## **SEAS REBUTTAL of APPLICANT'S RESPONSE TO SEAS REP3-140**

### **CUMULATIVE IMPACT**

**SEA LINK: EN020026**  
**DEADLINE: 5 – 10 March 2026**

**RE: SEAS rebuttal of 9.116 Applicant's Comments on Selected Other Late Submissions Received at Deadline 3 [REP4-236 Tables 3.1 and 3.2] – in particular comments on SEAS REP3-140 Cumulative Impact.**

Appendix A-1 Additional LionLink Cumulative Visualisations (sheet 2 of 4)

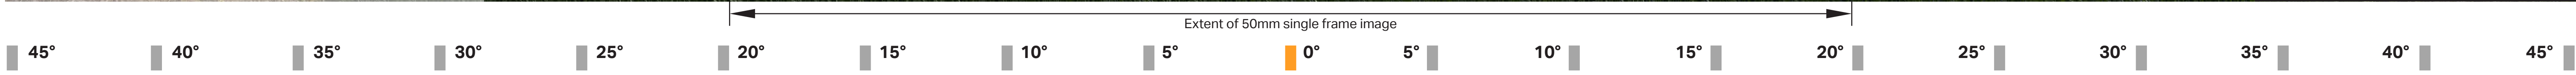
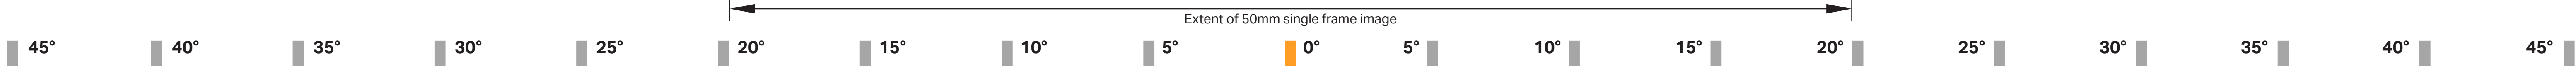
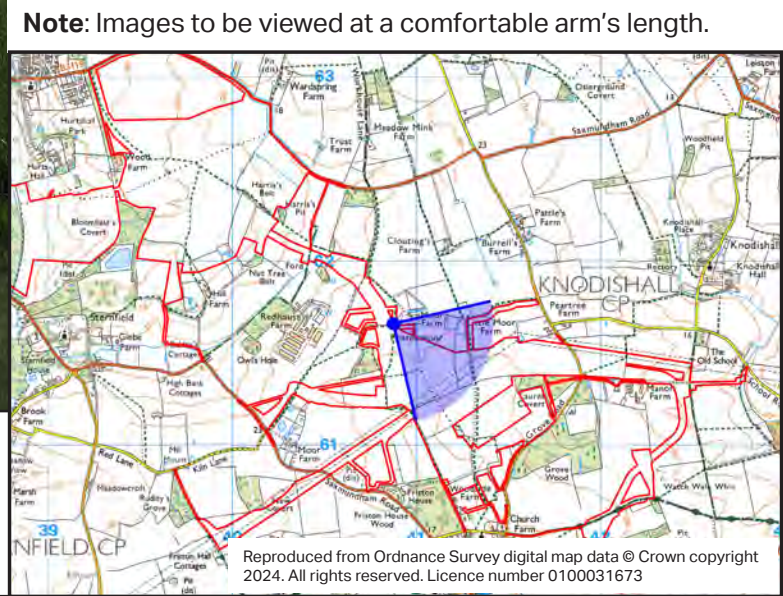
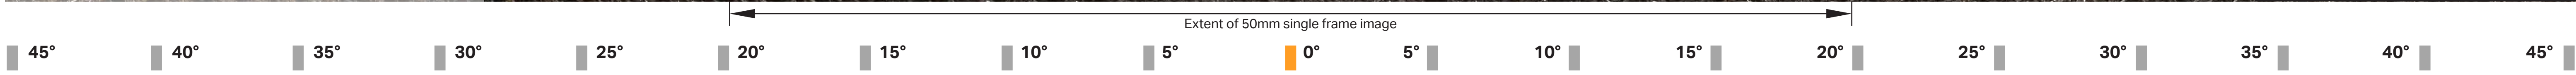
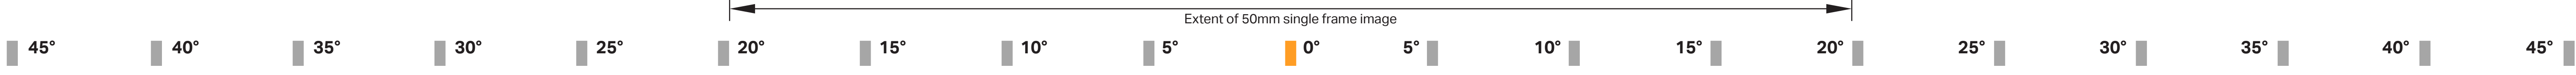
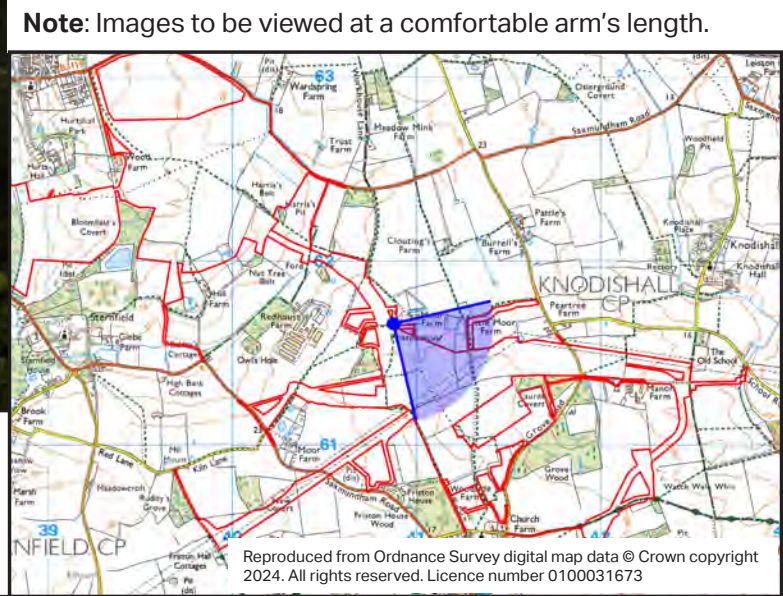
In several instances the Applicant also refers to the "LionLink Cumulative Visualisations" in Appendix A of REP4-086. These figures were produced following requests from the Examining Authority during ISH2 and do not address SEAS' earlier concern that cumulative visual assessment was absent from the original assessment. In addition these visualisations consist of simplified block models which do not provide the level of detail necessary to assess cumulative landscape and visual effects. These shortcomings prevent a meaningful assessment of how the combined Sea Link and LionLink infrastructure would be experienced in the landscape; this level of visualisation is not sufficient to allow a robust cumulative landscape and visual assessment.

<p>the Applicant’s claim that no usable information exists. Moreover, the Applicant already held sufficient indicative information, block massing from the Sea Link PEIR, footprints in APP-363, and the AS-064 envelopes to produce meaningful cumulative visuals long before NGV’s PEIR.</p> <p>The ExA requested cumulative photomontages, not dotted lines. The continued absence of proper cumulative visualisations remains unjustified and undermines transparent assessment of landscape and visual effects.</p>	<p><b>Hearing 2 (ISH2) [REP4-086].</b> These were informed by the statutory consultation material from LionLink that was published in January 2026 as set out in Appendix A.</p>	<p>provide the level of detail necessary to assess cumulative landscape and visual effects. These shortcomings prevent a meaningful assessment of how the combined Sea Link and LionLink infrastructure would be experienced in the landscape. Given the scale of the proposed infrastructure and the sensitivity of the receiving landscape, this level of visualisation is not sufficient to allow a robust cumulative landscape and visual assessment.</p>

8	<p>Why cumulative visualisations/ photomontages showing the LionLink converter station at Saxmundham are required</p>	<p>SEAS does not agree with the Applicant’s position. The Applicant’s reference back to REP1A-043 does not address the substance of SEAS’s point.</p>		<p>The Applicant has not provided any response to the point raised. SEAS notes that subsequent to this exchange the Applicant provided material described as “LionLink Cumulative Visualisations” within Appendix A of REP4-086. The Examining Authority has required the Applicant to review and update its cumulative effects assessment in light of further LionLink project information (EV6-033 Action Point 107), and the adequacy of cumulative</p>
